APPROVED
 Limited building only review
 Permit holder responsible for full compliance with the code

PLAN:
 Taggart w/
 Porch

SHEET TITLE:
ELEVATIONS

PROJECT ADDRESS:
 475 Solomon Dr.
 Liberty Meadows Lot 76

SHEET TITLE:
2nd FLOOR

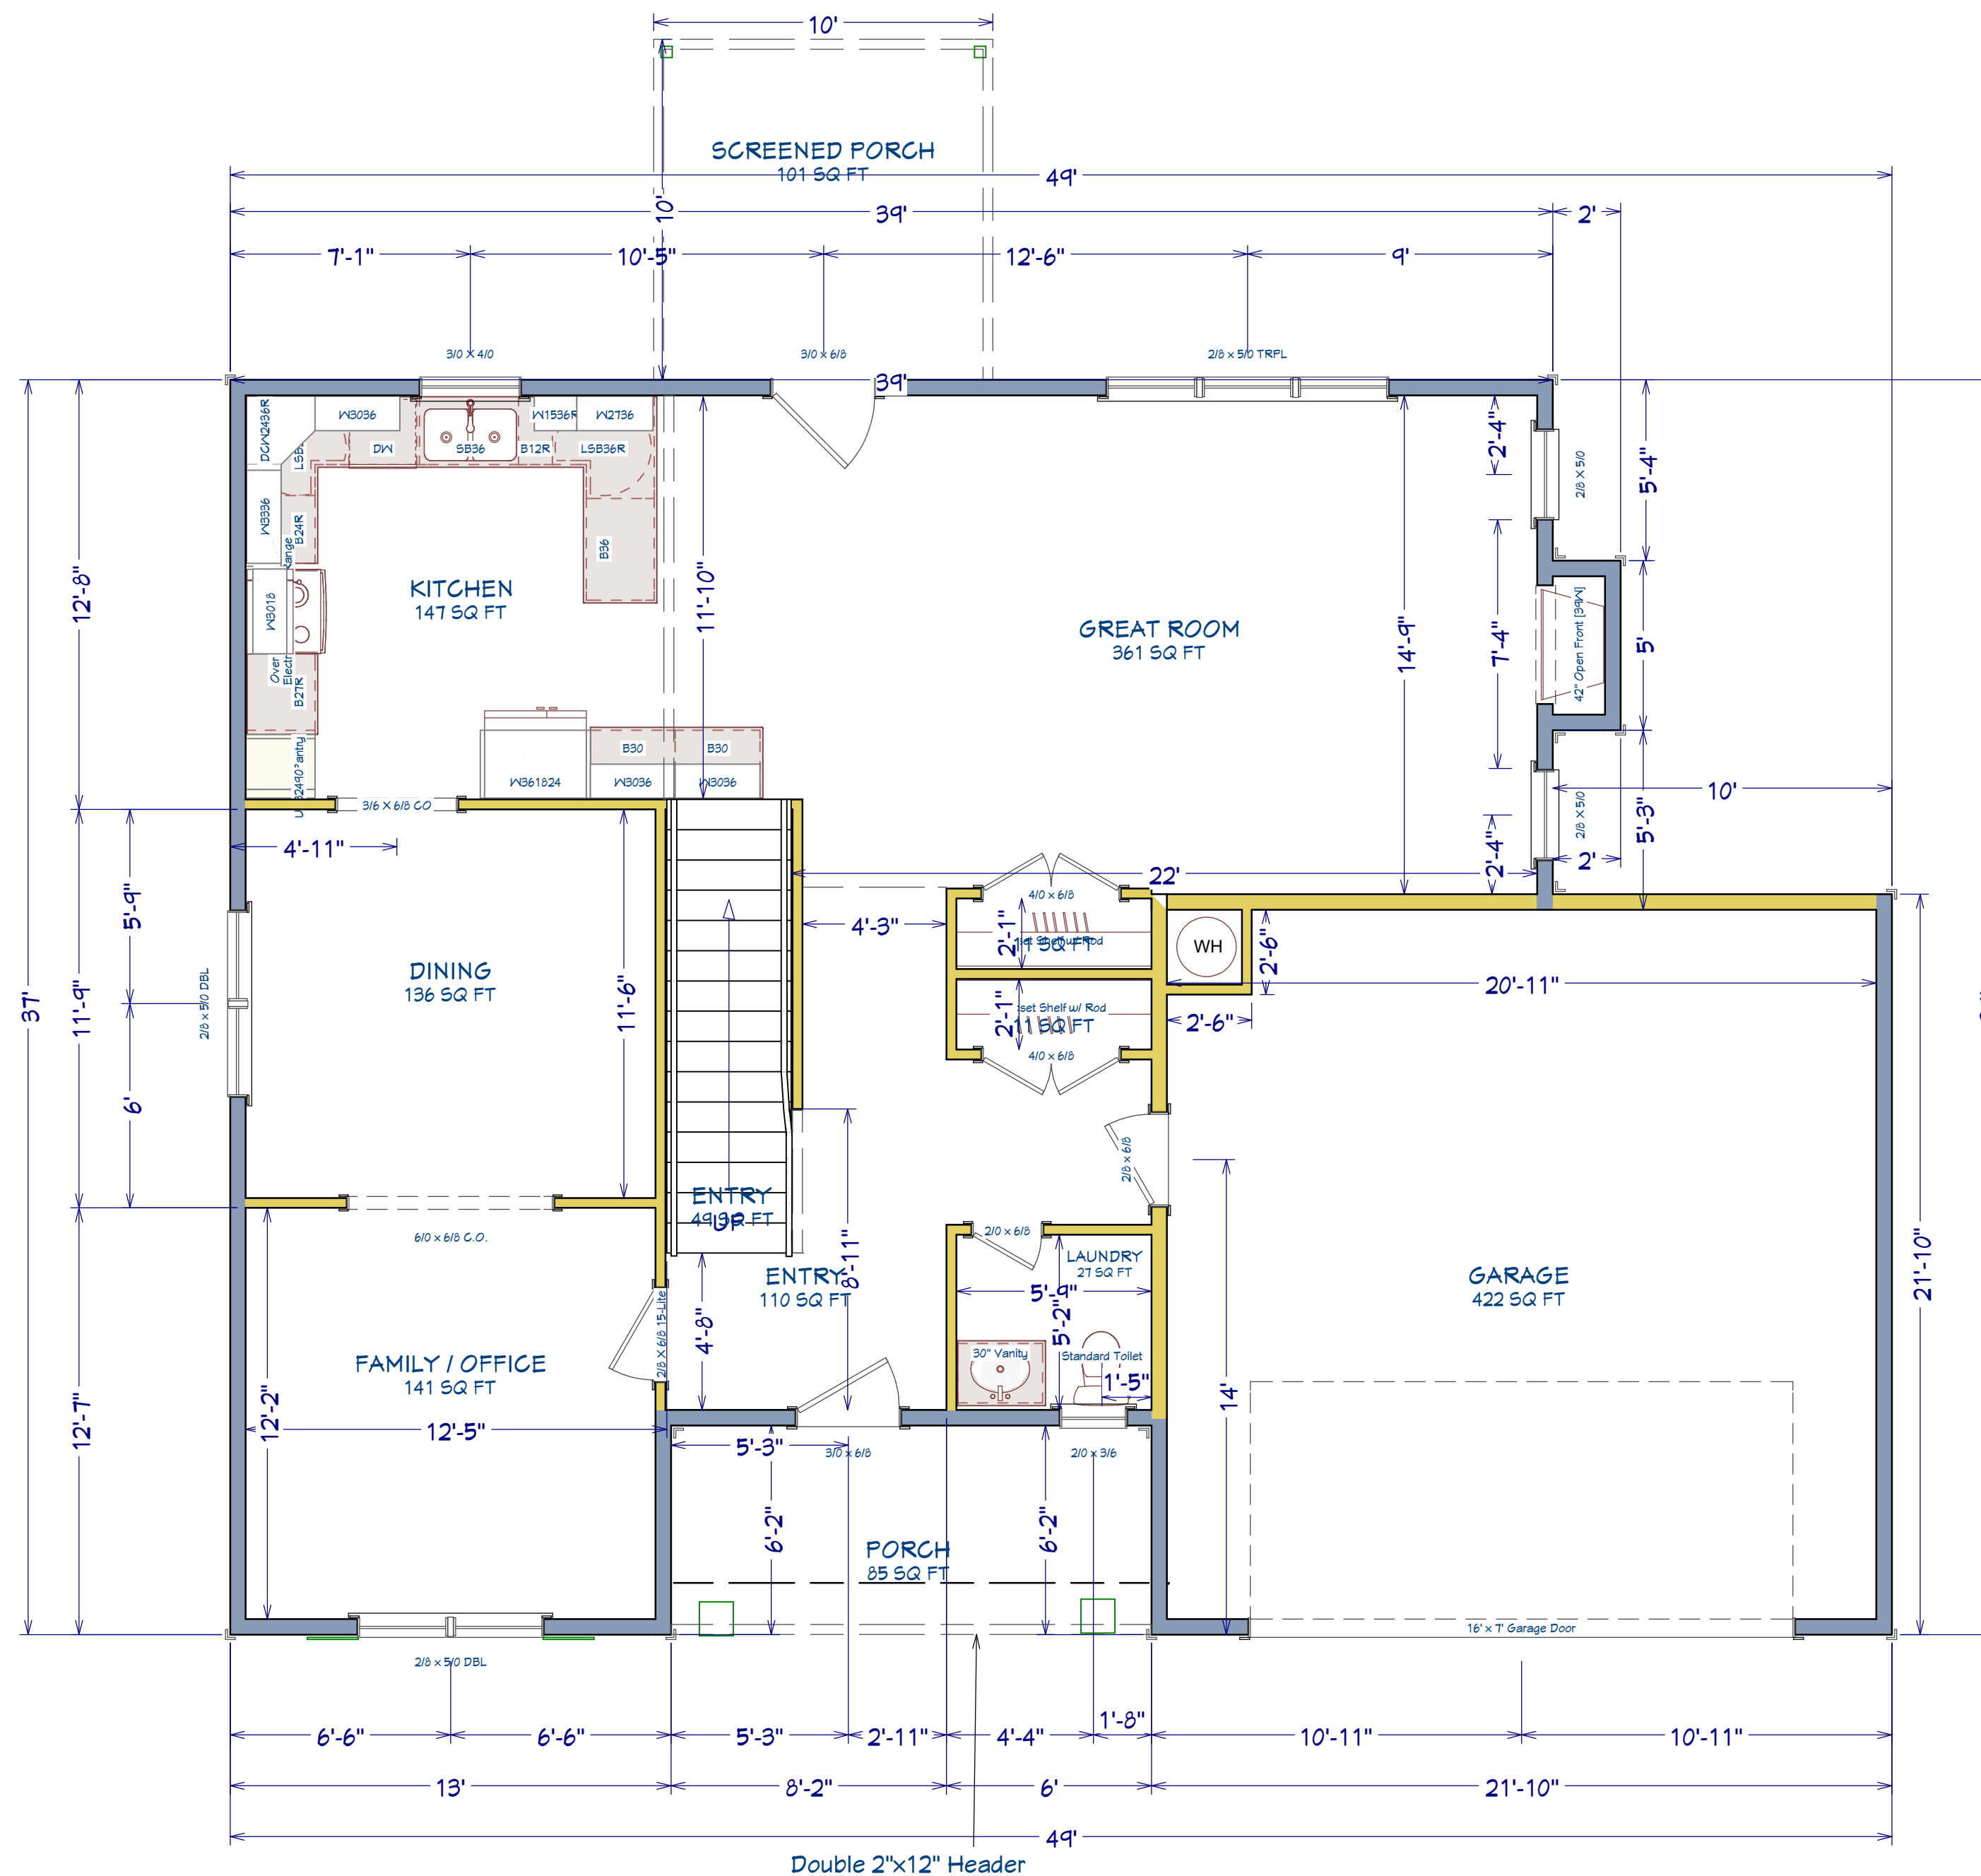
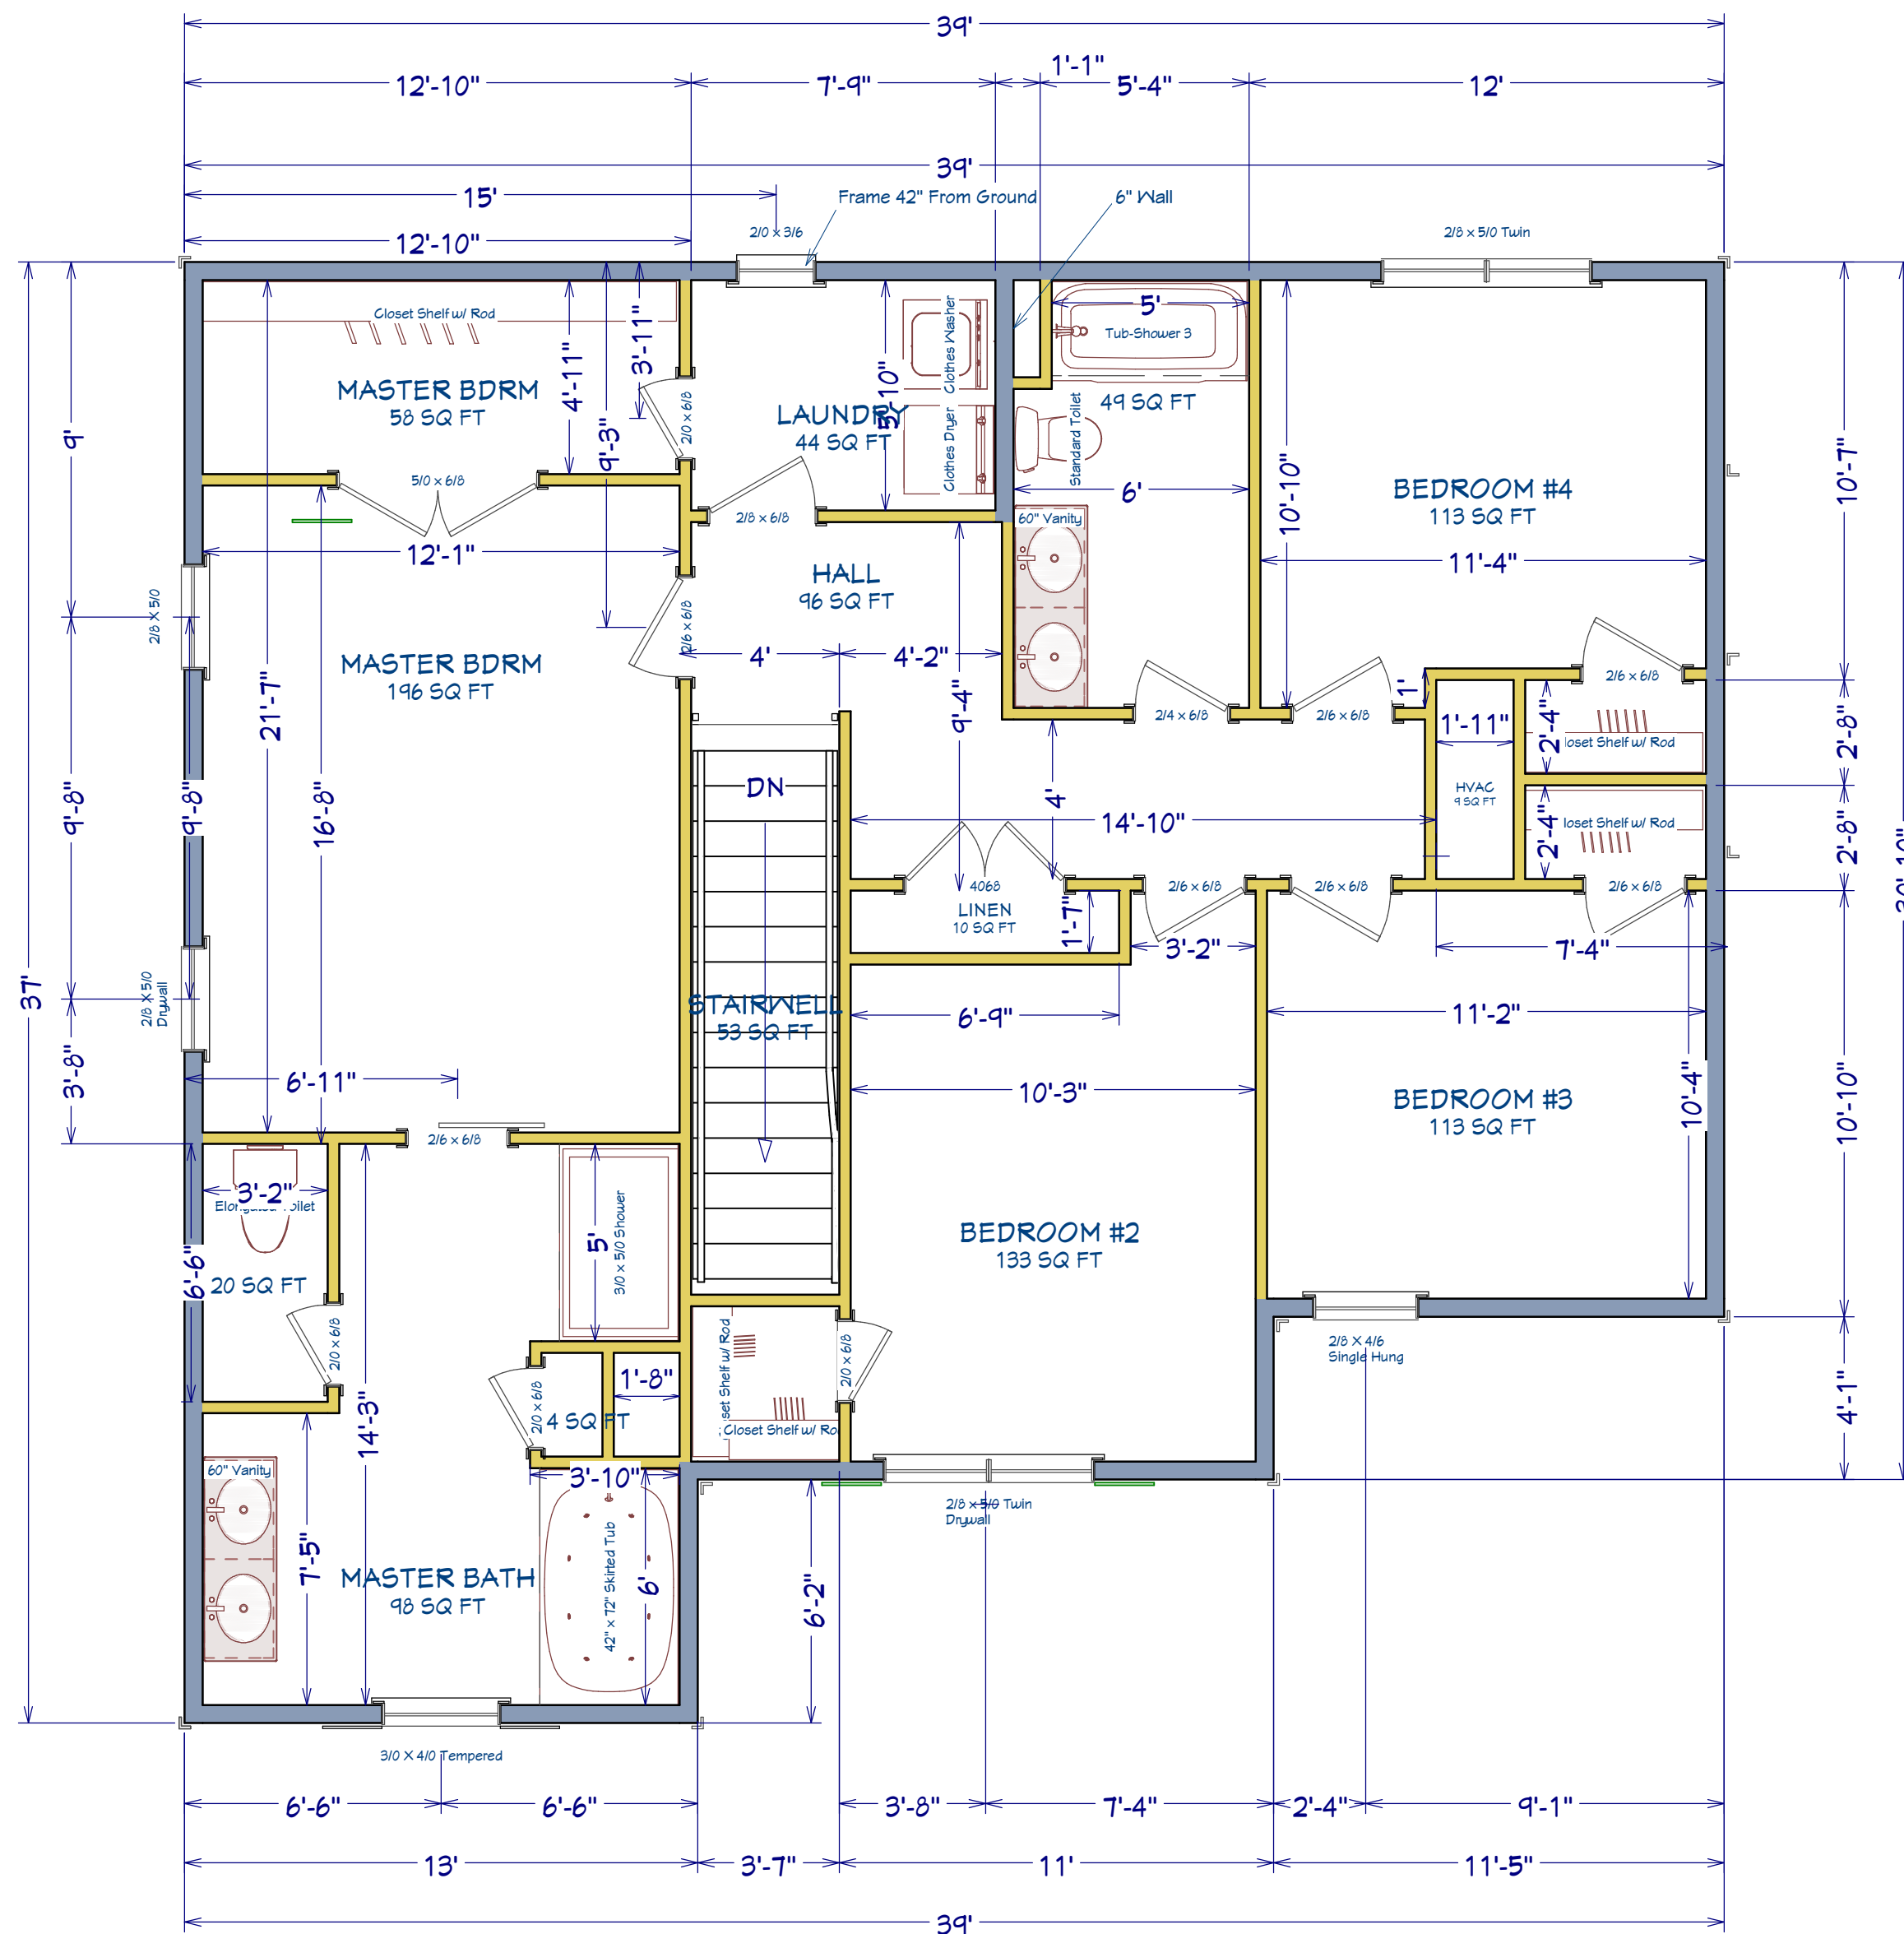
Verify Egress
